Ribble Valley Borough Council
Housing & Development Control

Application no: **3/2019/0854**

Address: **61 Ramsgreave Road Ramsgreave BB1 9BH**

Proposal: **Construction of single storey extension to rear. Conversion of existing attached garage to habitable room and addition of pitched roof.**

PROPOSED PARKING TWO CARS

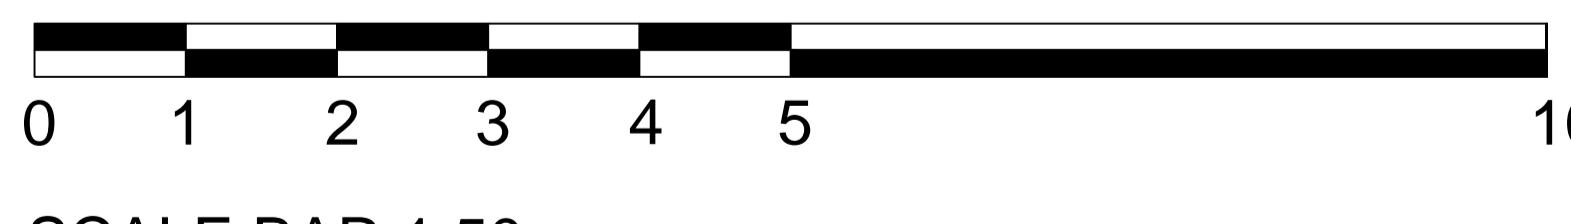
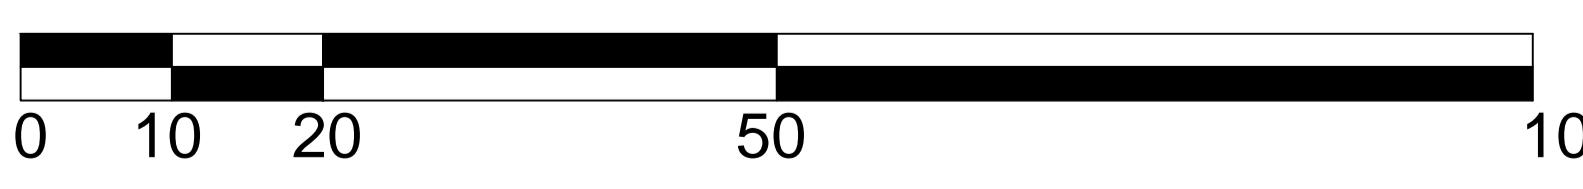
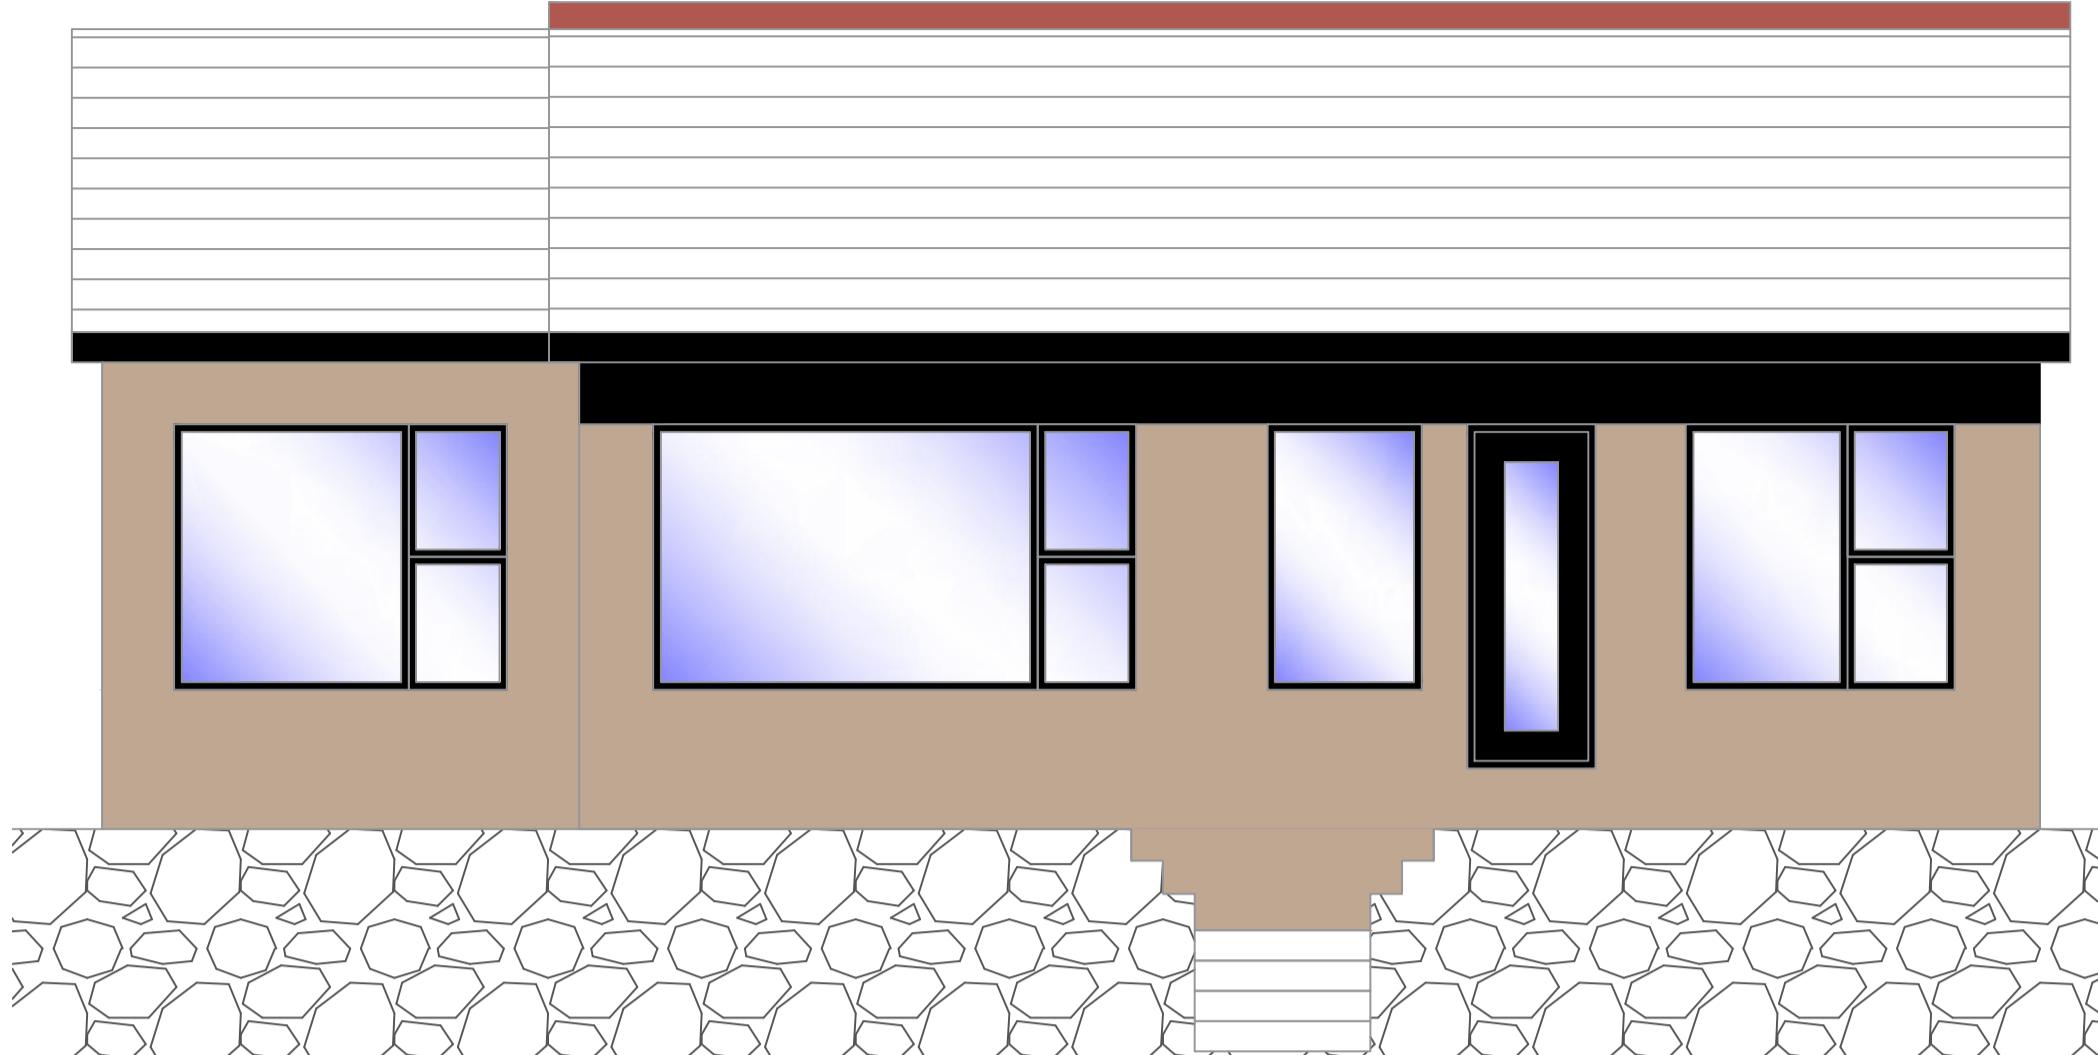
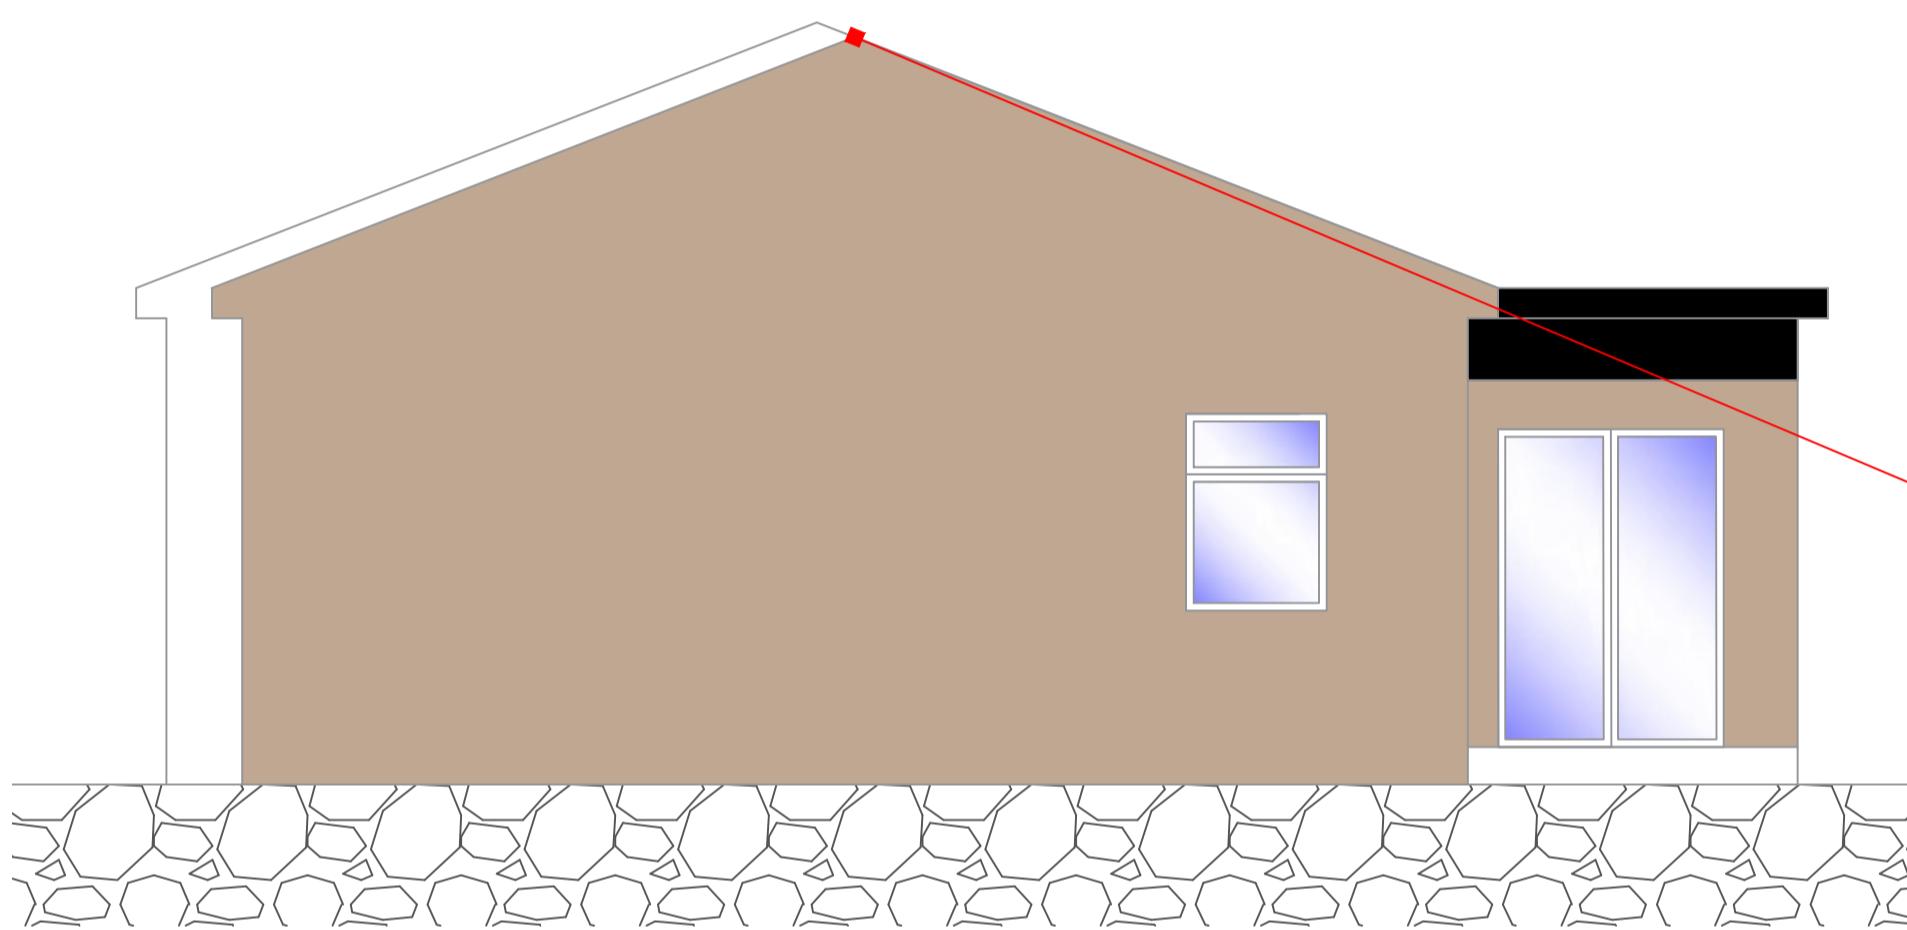
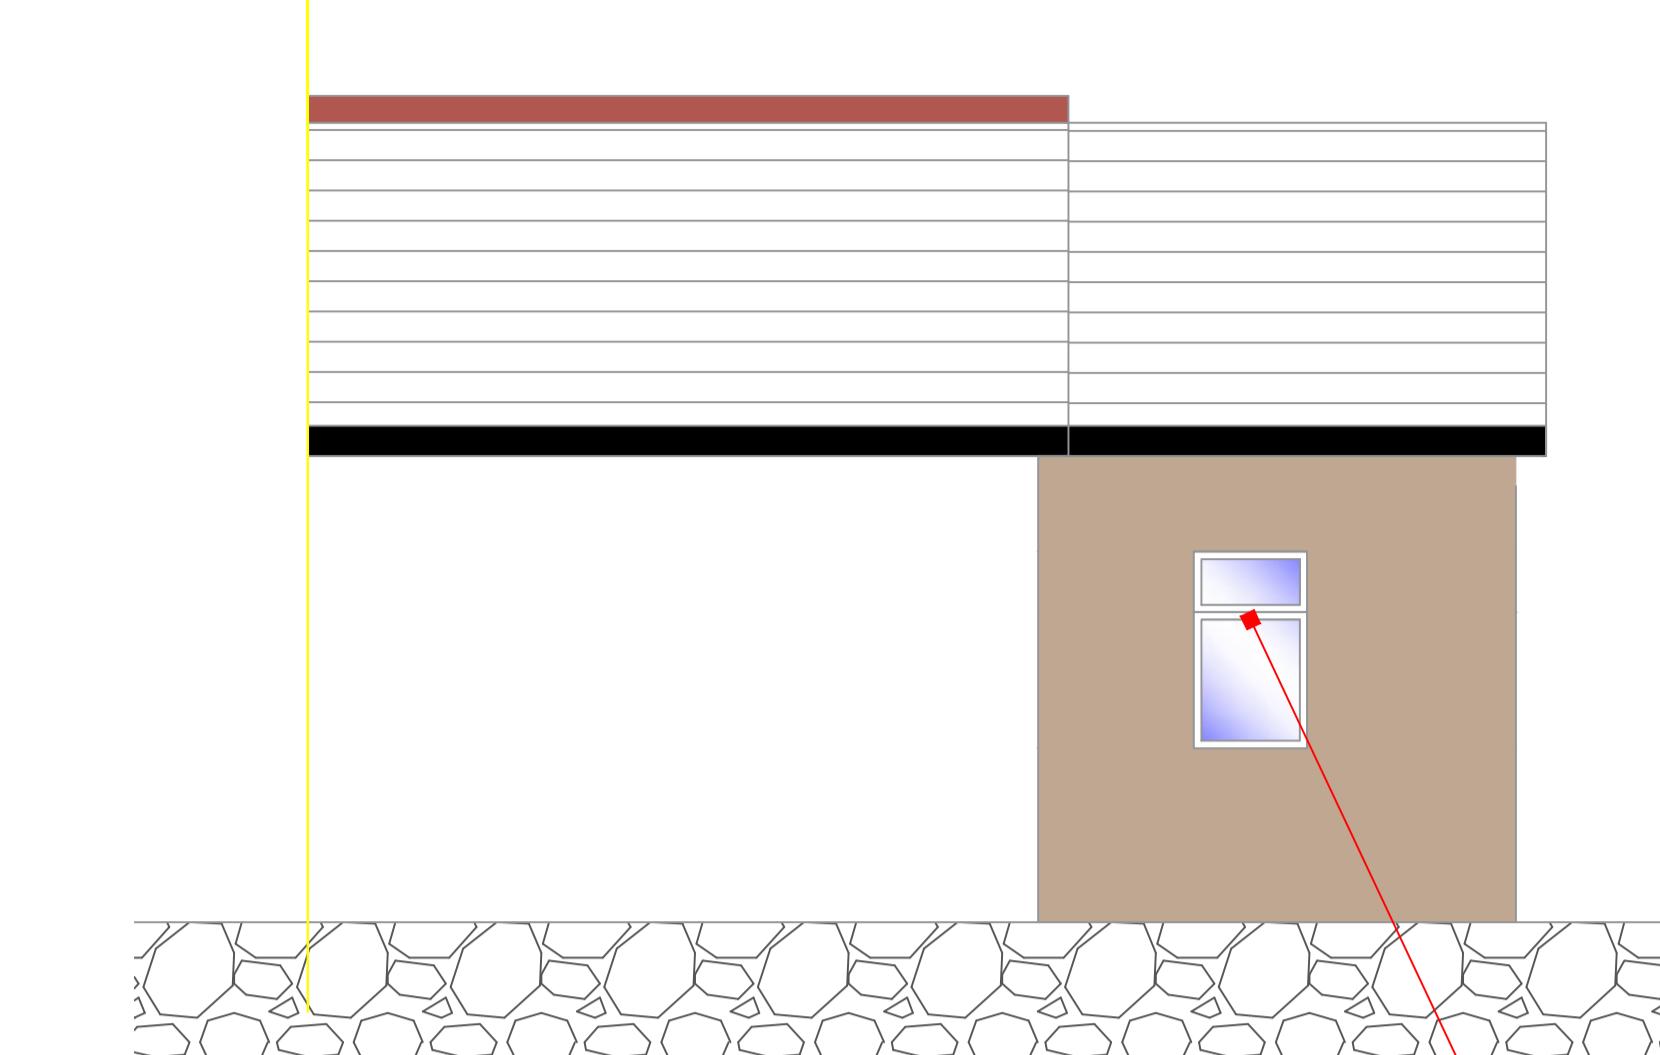
Whilst the parking provision will be retained as part of the proposal, there has not been any parking arrangements submitted as part of the planning application. The applicant proposes to convert the garage into a bedroom and whilst the frontage of the dwelling appears to have sufficient space to accommodate two parking spaces, the image of the small car on the existing driveway within the existing plans suggest that the existing parking arrangements fronting the dwelling does not comply with current standards and therefore the local highway authority would ask that the applicant submits a plan demonstrating the proposed parking arrangements.

The existing parking arrangements as detailed is considered substandard and could potentially result in vehicles overhanging the adopted pedestrian footway and causing obstruction to the detriment of pedestrian safety. Furthermore, the overhang of any vehicles within the adopted footway could reduce or obstruct the visibility of any vehicles exiting the neighbouring properties and thus the plans would need revising to provide the provision of sufficient parking in line with the required standards. The current dimensions for two perpendicular parking spaces whilst also allowing pedestrian access to and from the property is 6m x 5.5m.
